**WEST SUSSEX COUNTY COUNCIL  
STRATEGIC PLANNING CONSULTATION**

**SUBJECT: AL/66/14/PD - Prior Notification Under Class MB for change of use from agricultural building to 2 No. dwellinghouses (Use Class C3)**

**Sack Lane Dairy, Sack Lane, Lidsey, Bognor Regis, West Sussex**

Site Plan
scale 1:200

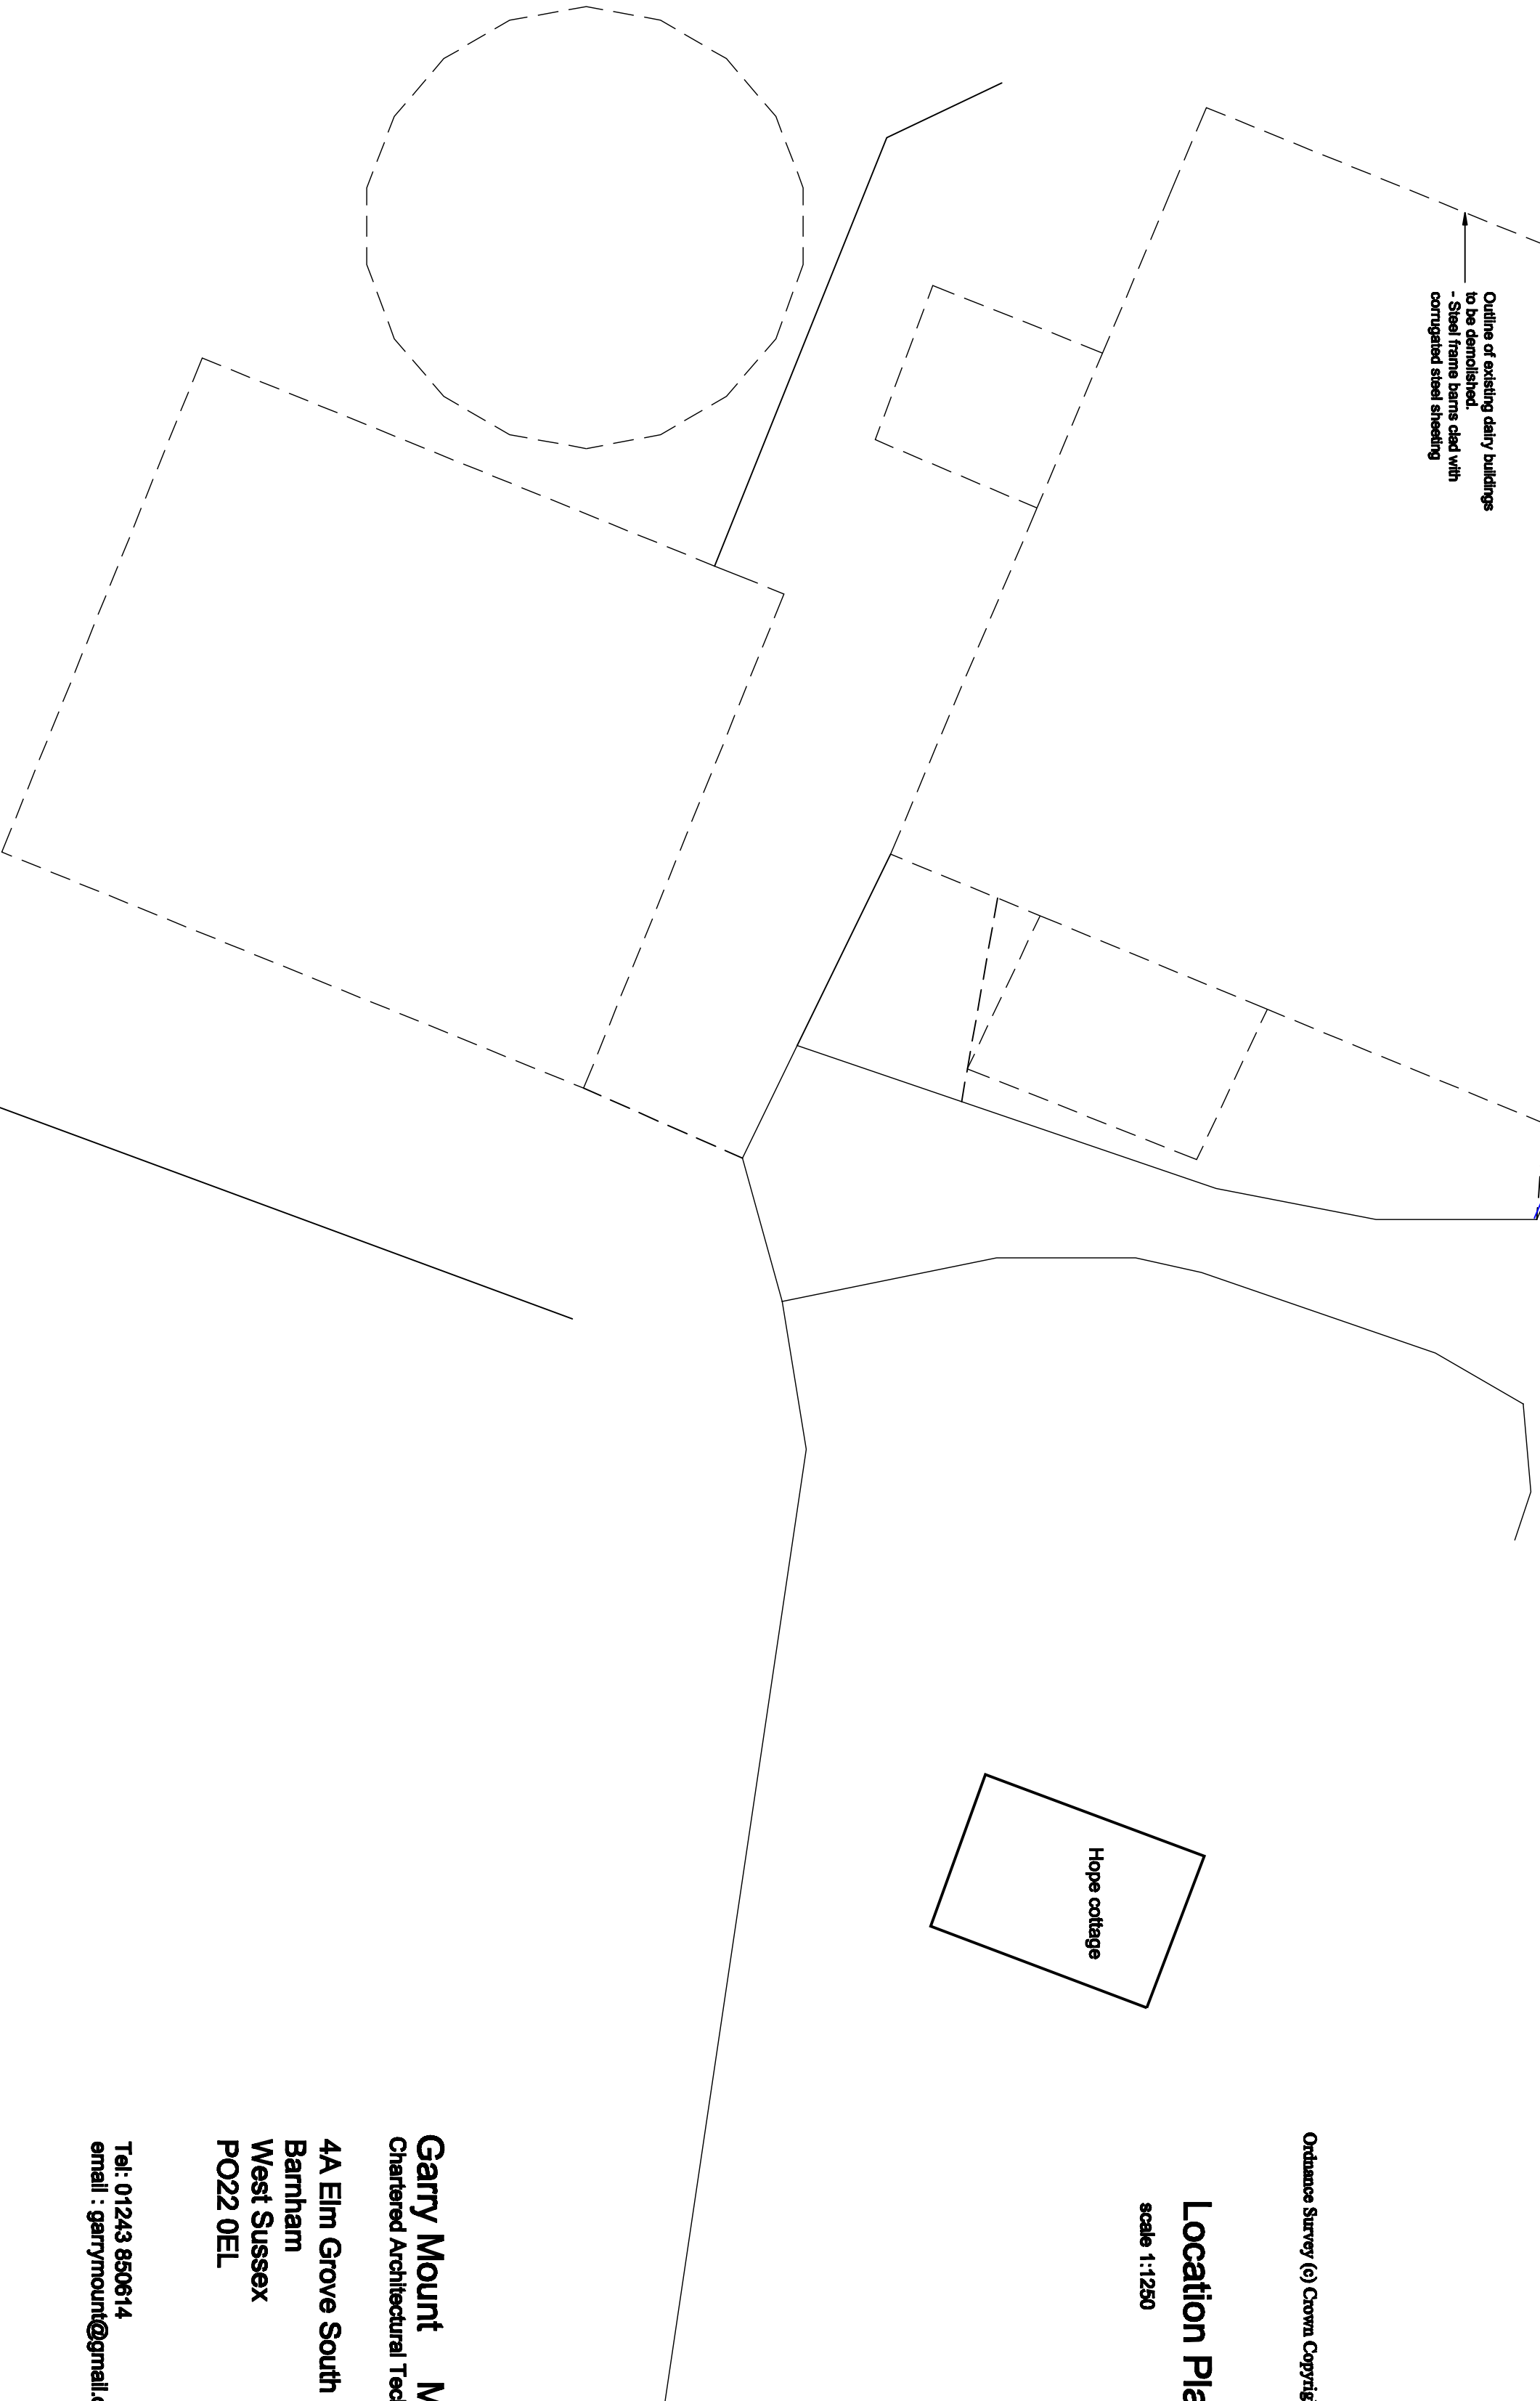
4 x Vehicle and a cycle parking provision are proposed. It would be anticipated that two dwellings of this size in this location would create the demand for 5 parking spaces. This shortfall of one space is likely to be required for visitor parking and could be accommodated within the hard standing of the site.

The application site is served via an existing point of access from Sack Lane. At this point Sack Lane is considered private and not maintained by the Highways Authority.
